Your Ref: H17-1187-21

FULL

Residential Development of 48 dwellings with associated garages, roads and sewers.

Land off Sunnydale Close Surfleet

DRAWING No:
118 - SL - 01

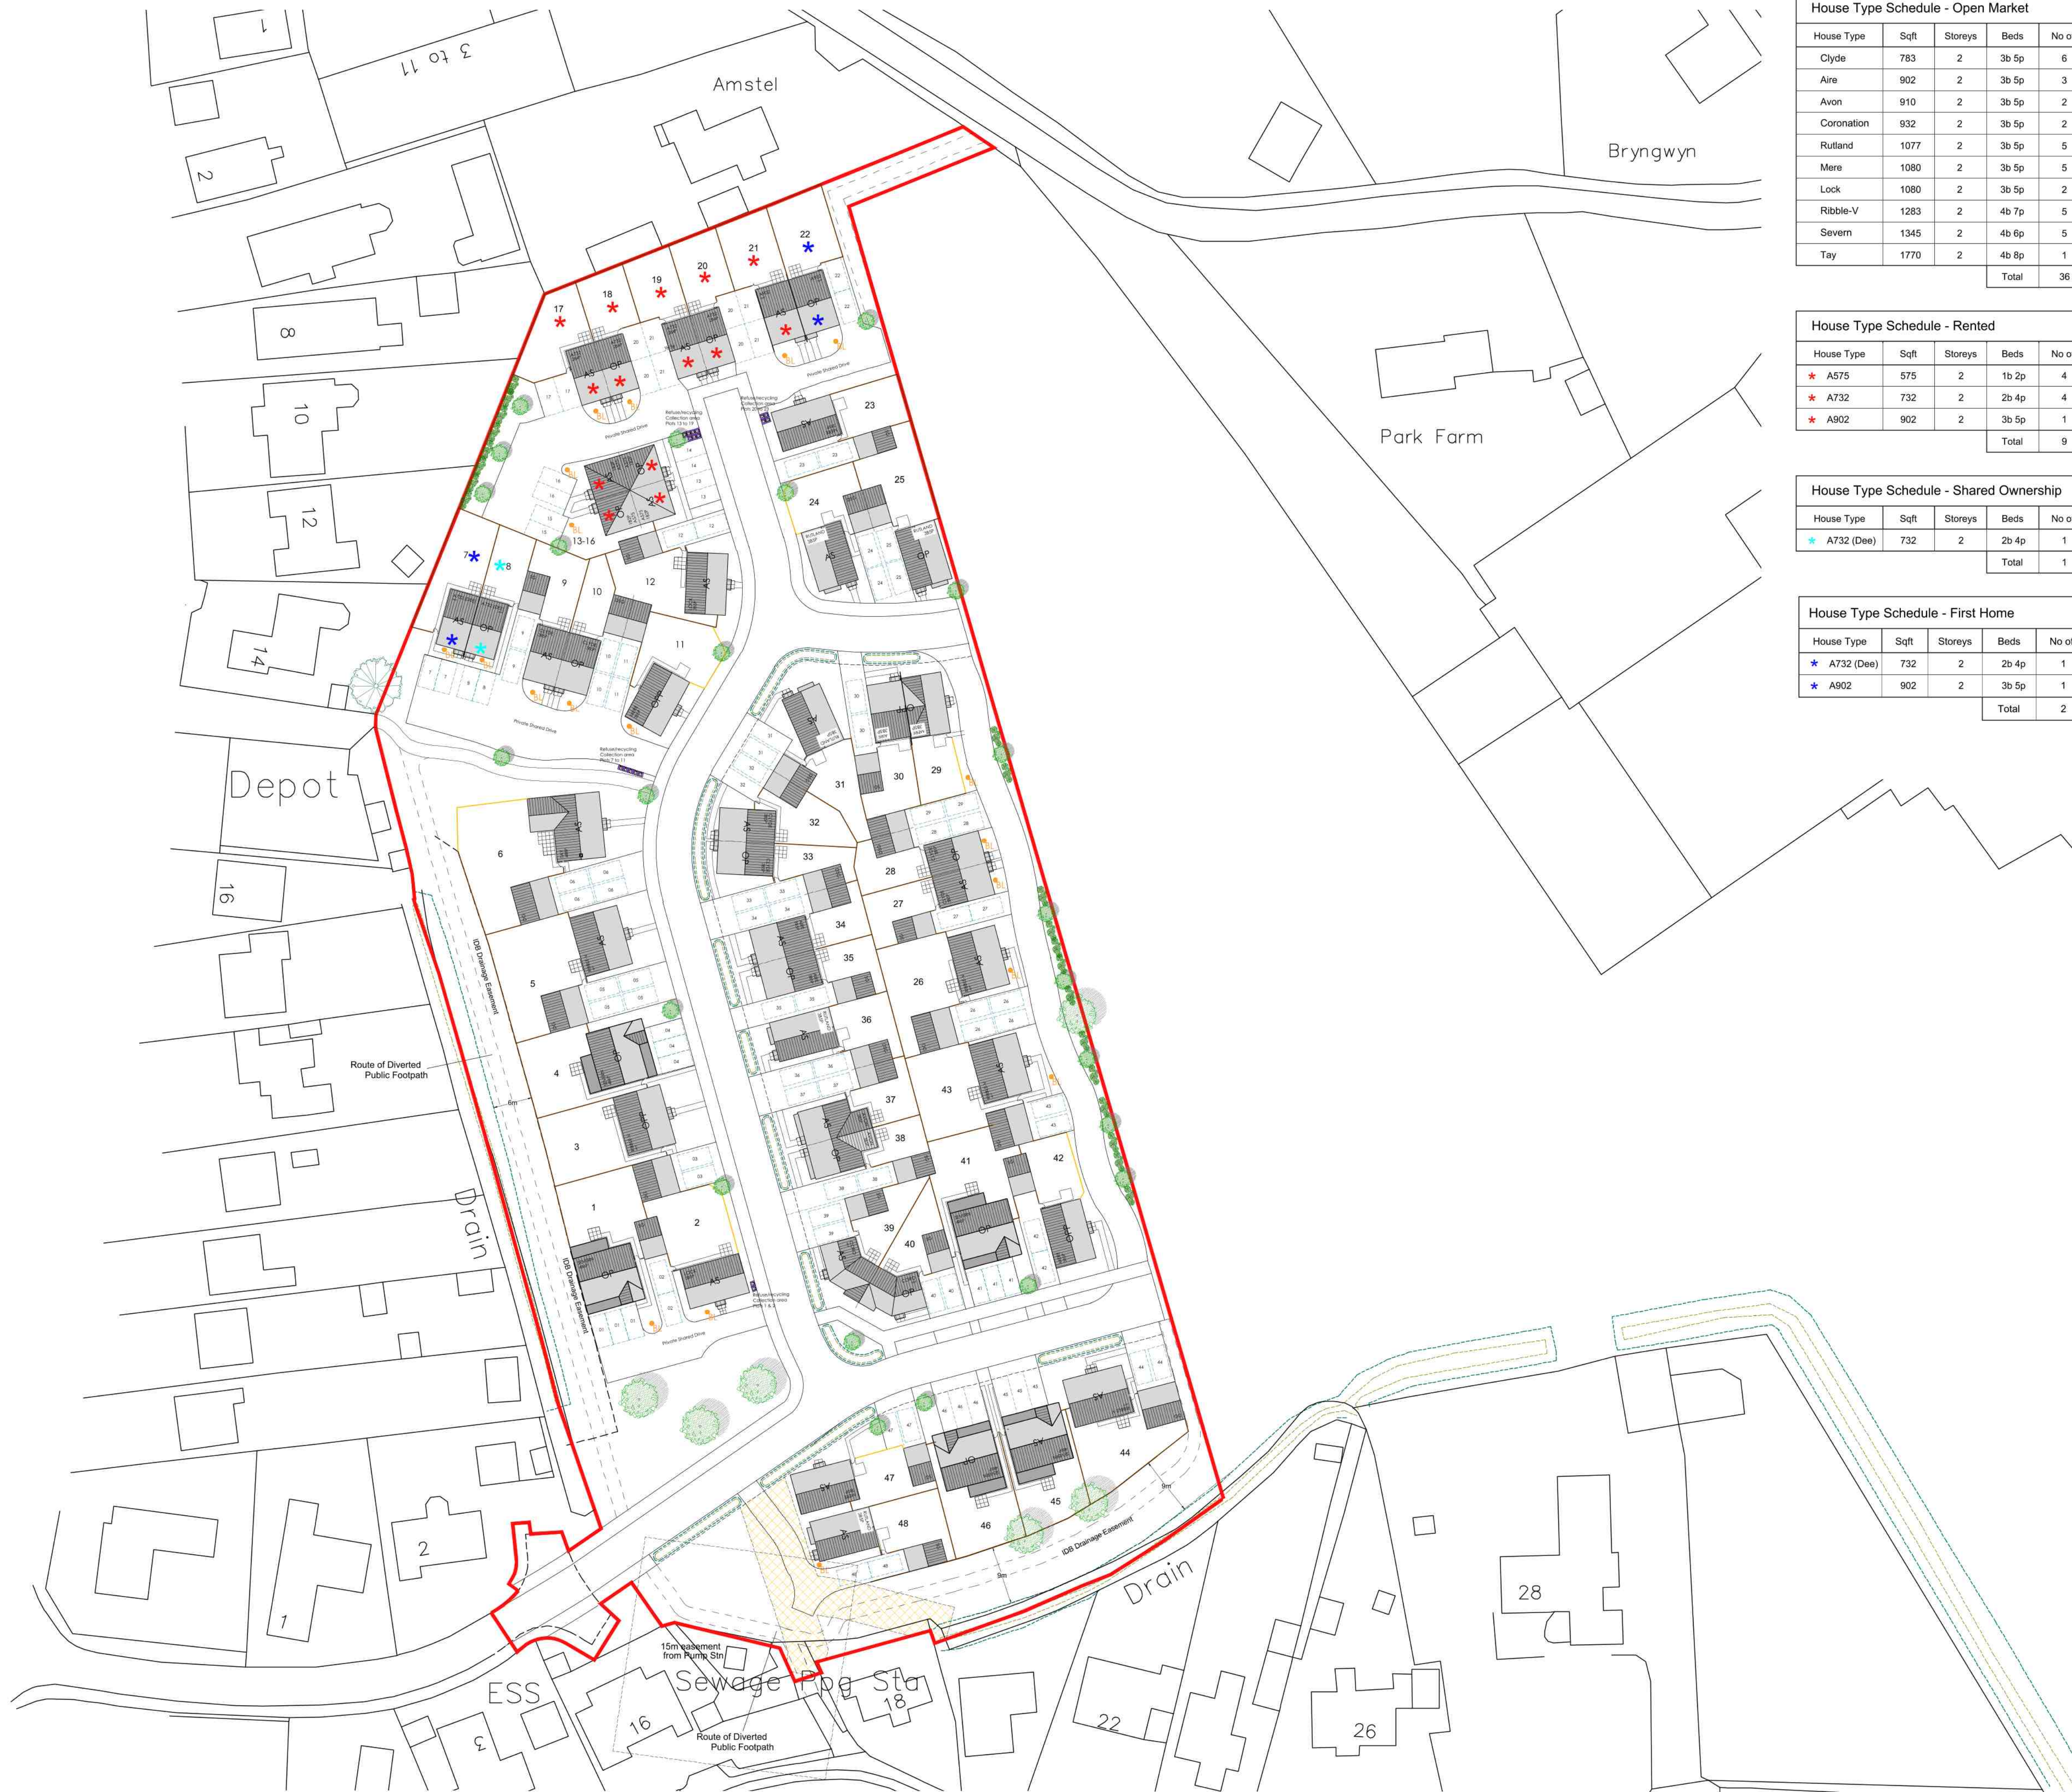
It is noted that on some of the unit's rear access footpaths are indicated therefore the comments above should be carefully considered.
